# Rezoning Transportation Analysis

Petition Number: #2022-091

## Revision Log:

Date	Description
11-28-22	First Review (IW)
01-27-23	Second Review (IW)
02-13-23	Third Review (DR)
02-22-23	Forth Review (IW)

RZ-1.0

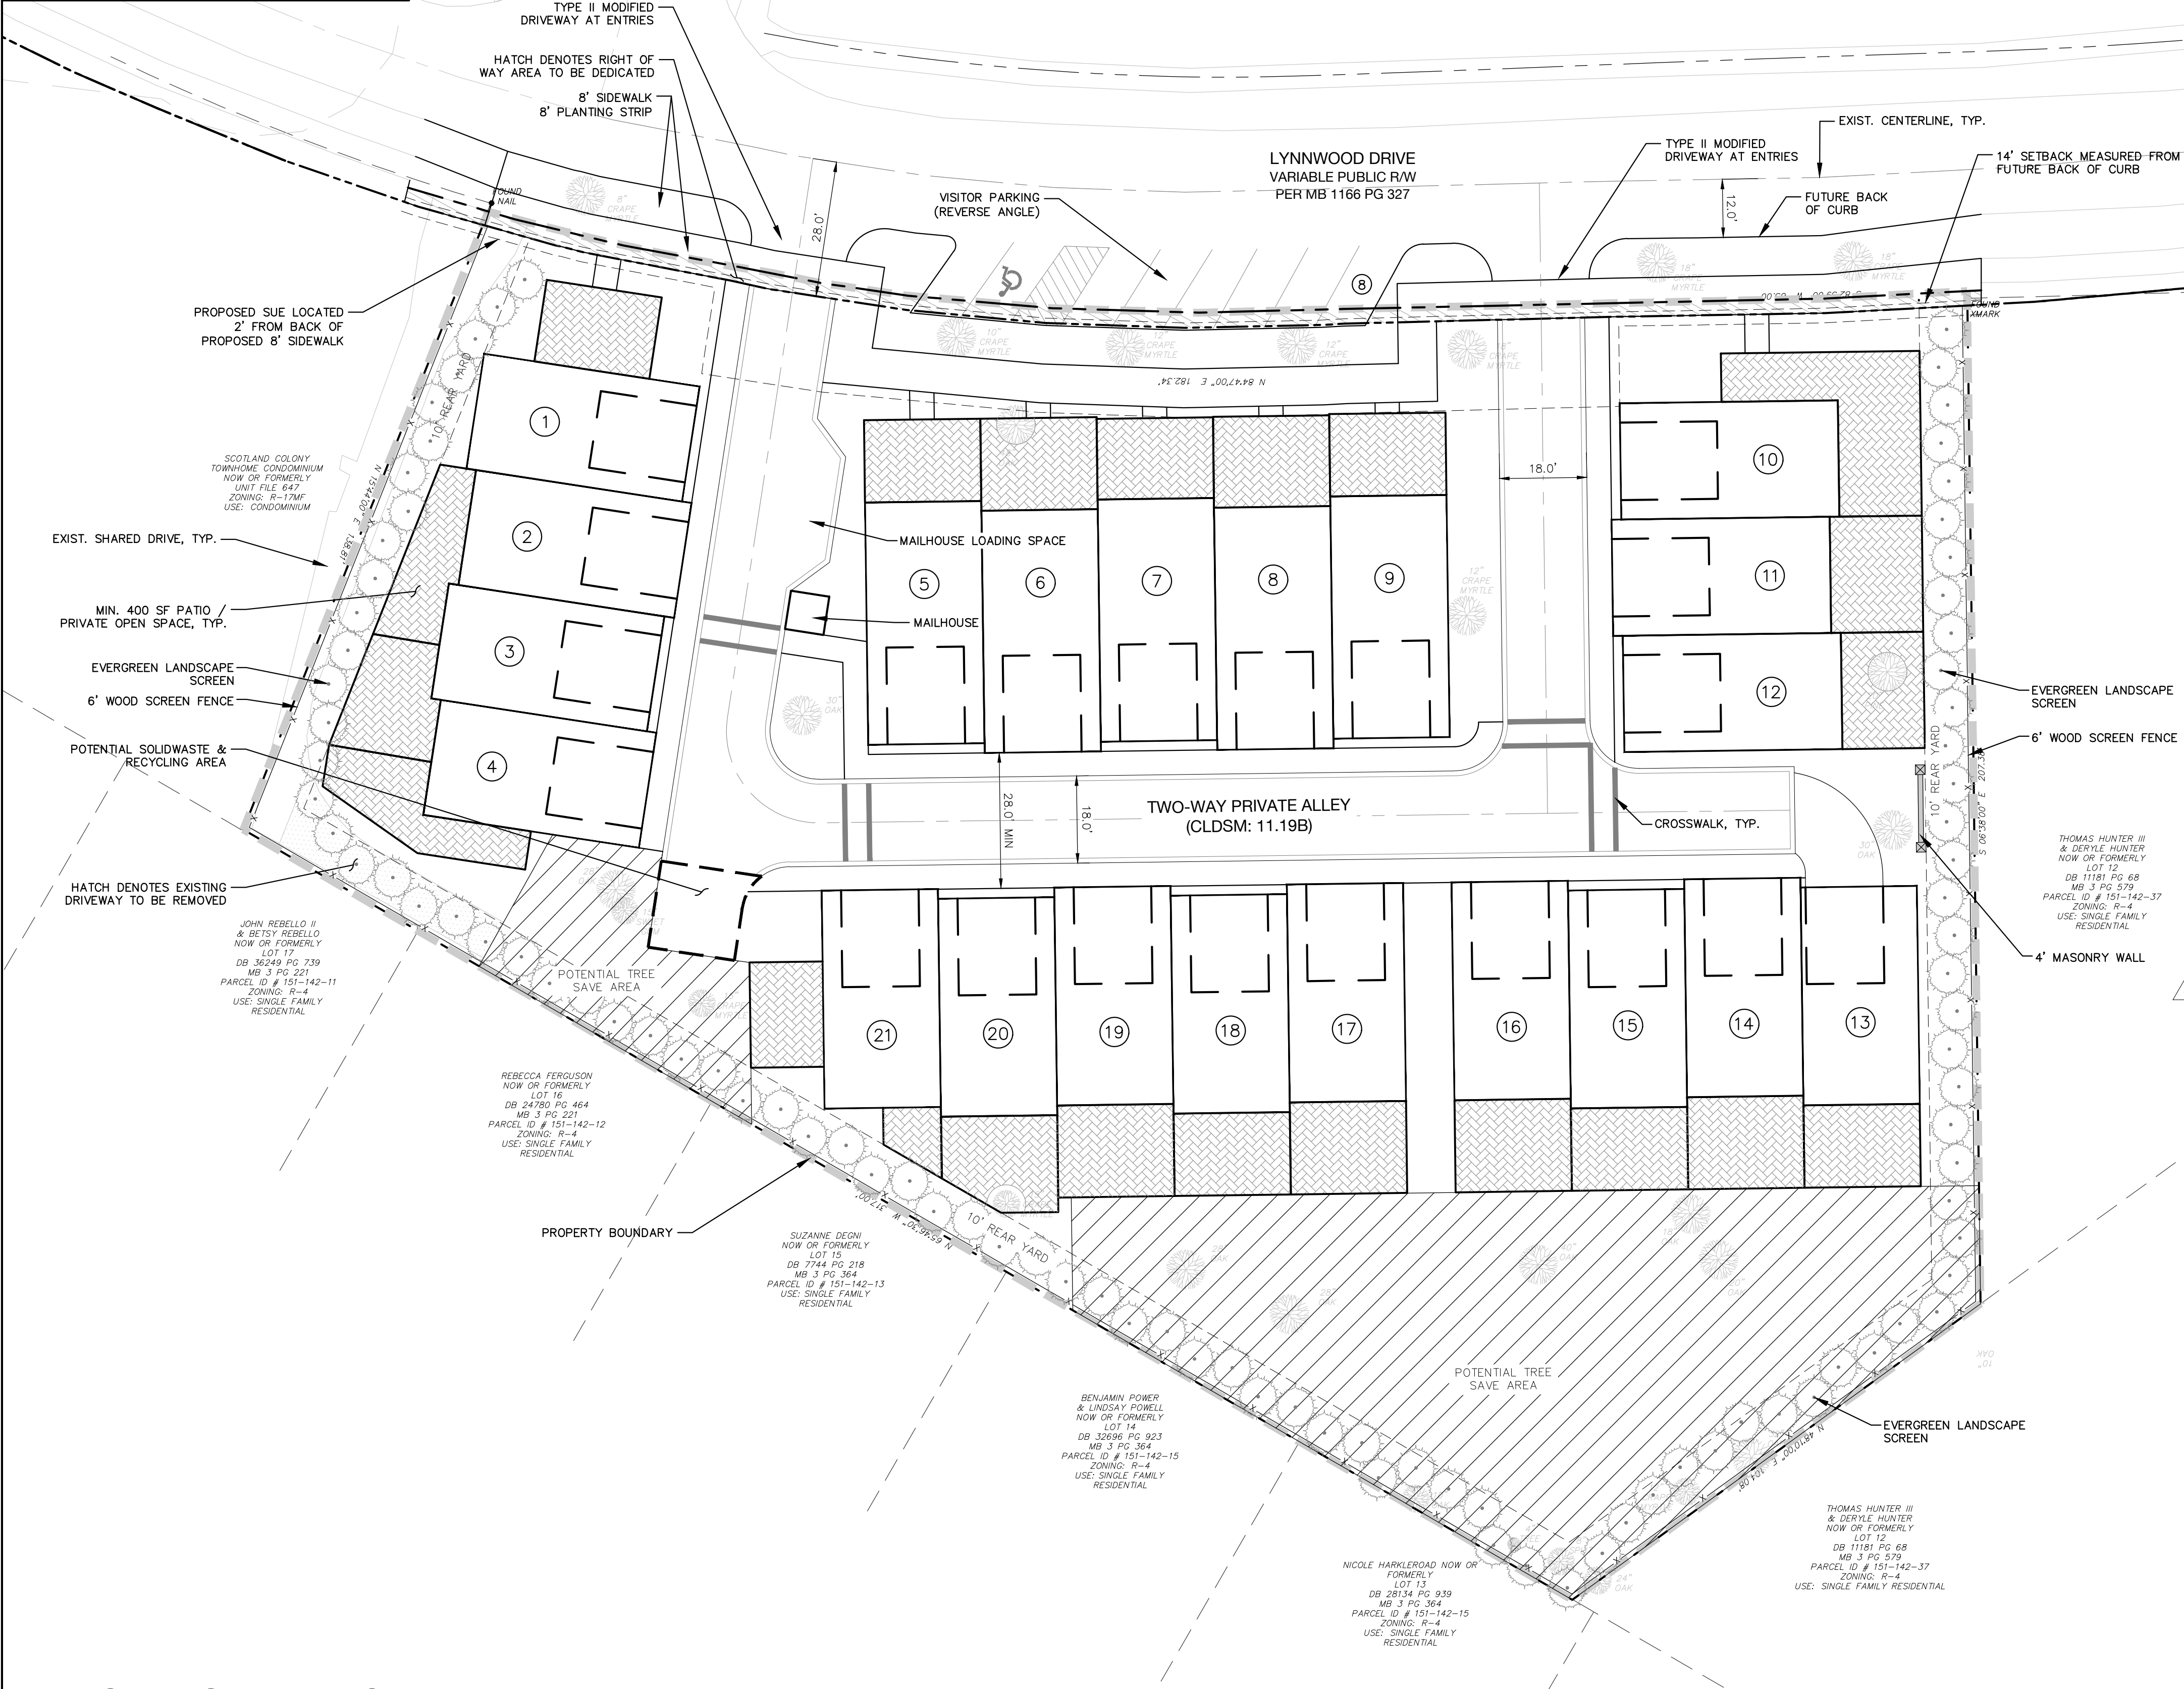
- Outstanding comment from 11-28-22 Curblin:** The proposed zoning district has a setback measured from back of the existing or proposed future curblin.
  - Lynnwood Drive:** The future location of curb and gutter should follow the CLDSM Local Residential Medium Street which is measured at 13-feet from the centerline of the roadway to the BOC.  
**Clarifying comment 01-26-23:** Site plan should show dimension from centerline to back of curb.

Label and dimension the curb and gutter from the centerline for each road on the site plan.

7. ~~Outstanding comment from 11-28-23:~~ A site plan note(s) specifying dedication and fee simple conveyance of all rights-of-way to the City before the site's first building certificate of occupancy is issued as needed. CDOT requests rights-of-way set at 2' behind back of sidewalk where feasible.

~~Clarifying Comment 01-27-23:~~ Site plan should update conditional note 7 under Transportation to state SUE to be 2' behind sidewalk and not 1' so that CDOT can do maintenance when necessary.
